ASSESSMENT REPORT
Section 75W Modification
d'Albora Marina The Spit, MP08_0046 MOD 1

MPO80046 MODIFIED PLAN DA01/W

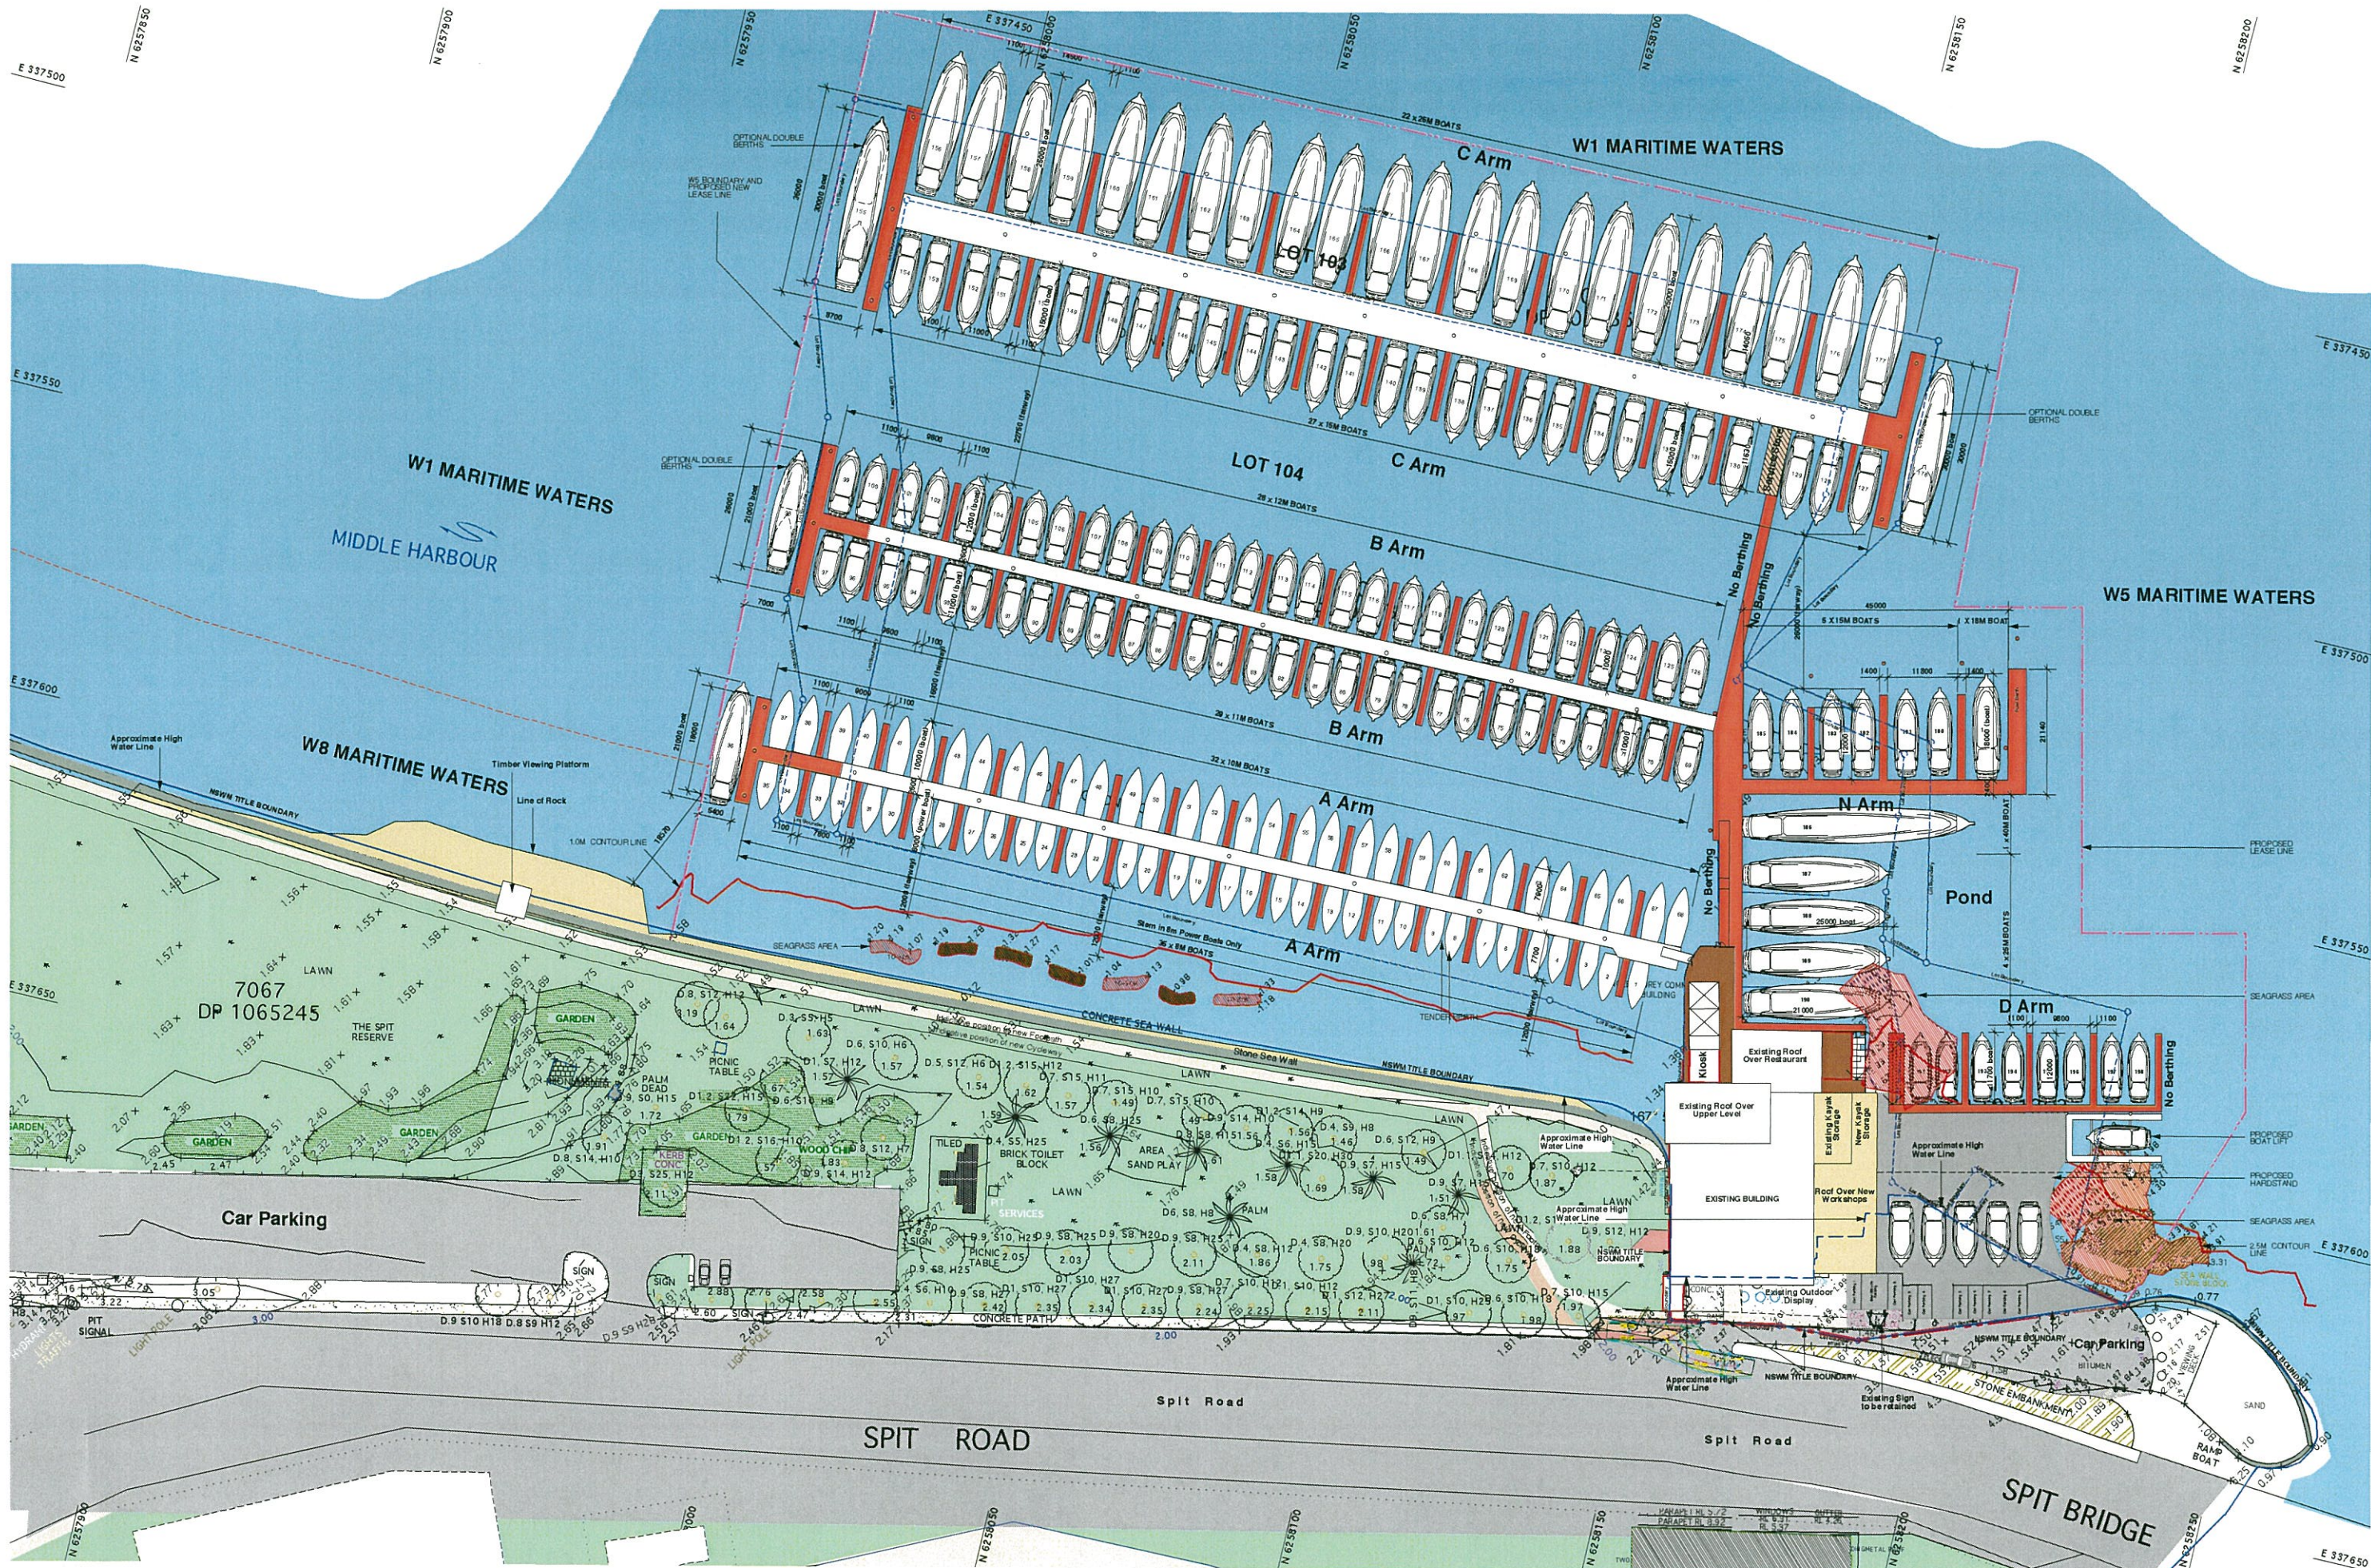
The connecting walkway between B Arm and C Arm is being relocated to line up with the main access from the marina buildings. There will be improved passive surveillance on the pedestrian access along the marina.

It is proposed to relocate the fuel wharf into deeper water. This will allow for improved navigation and larger vessels to access. RMS Maritime have no issues with the proposed fuel wharf position and the proponent must comply with navigation regulations.

With the relocation of the fuel wharf to N Arm, it is proposed to construct a replacement floating berthing finger replacing the approved fuel wharf location at D Arm. This reconfiguration does not alter the approved berth numbers. The Department notes RMS has conditioned there is no berthing on the outside of the proposed end floating berthing finger of D Arm.
